September 16, 2021

Re: Grandview Reserve, Filing No. 1 (File # PUDSP2110)
Parts of the S½ of Sec. 21 and N½ of Sec. 28, Twp. 12S, Rng. 64W, 6th P.M.
Water Division 2, Water District 10
Upper Black Squirrel Creek Designated Basin

We have reviewed the September 14, 2021 referral concerning the above-referenced proposal to subdivide 189.5 acres into 568 single-family lots, an institutional parcel (for a church or similar use), and open space. This office previously provided comments on the entire Grandview Reserve PUD (containing 768.23 acres) on May 22, 2019.

WATER SERVICE AREA
GRANDVIEW RESERVE
METRO DISTRICT

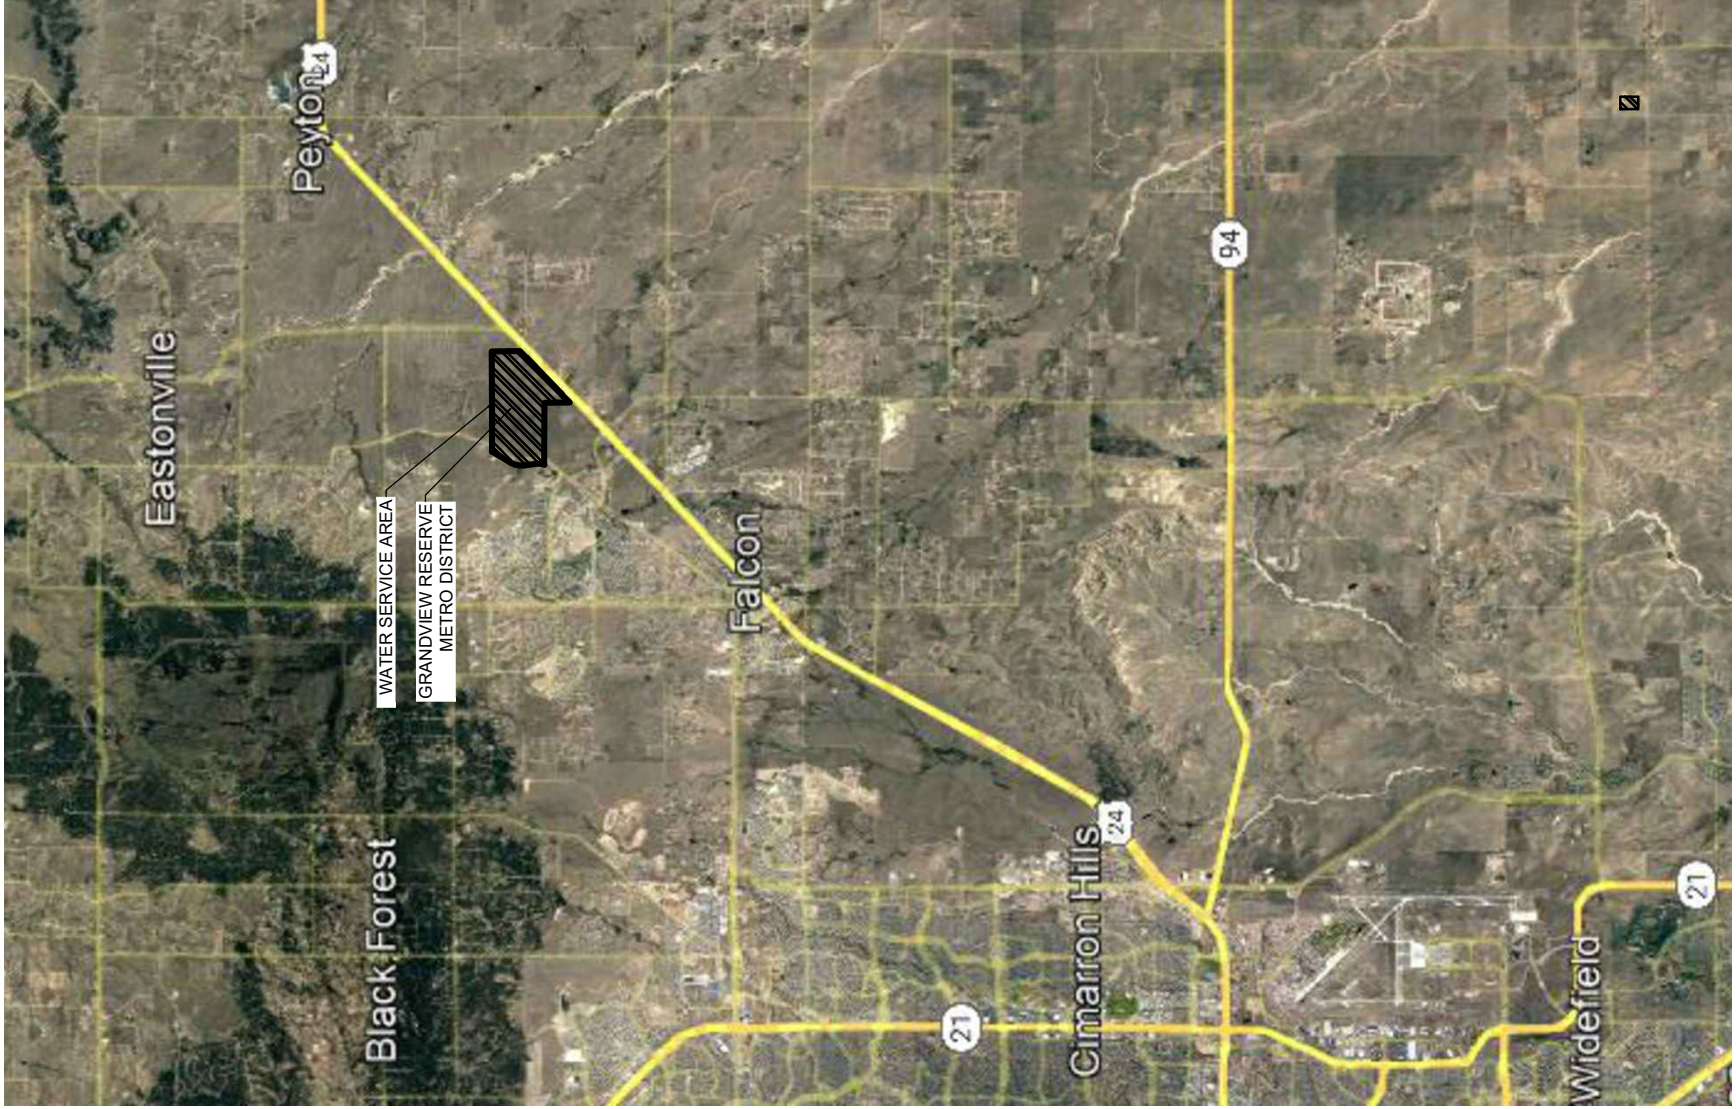
1. Clarification of the estimated water demand for Filing No. 1 that satisfies El Paso County's 300-year water supply requirement.
2. A map of GRMD's service area.
3. A complete summary of the water rights owned and controlled by GRMD, and evidence of that ownership or control.
4. The present demand on GRMD and the anticipated demand due to commitments for service entered into by the district that are not yet supplied.
5. The amount of uncommitted firm supply GRMD has available for future commitment and development.
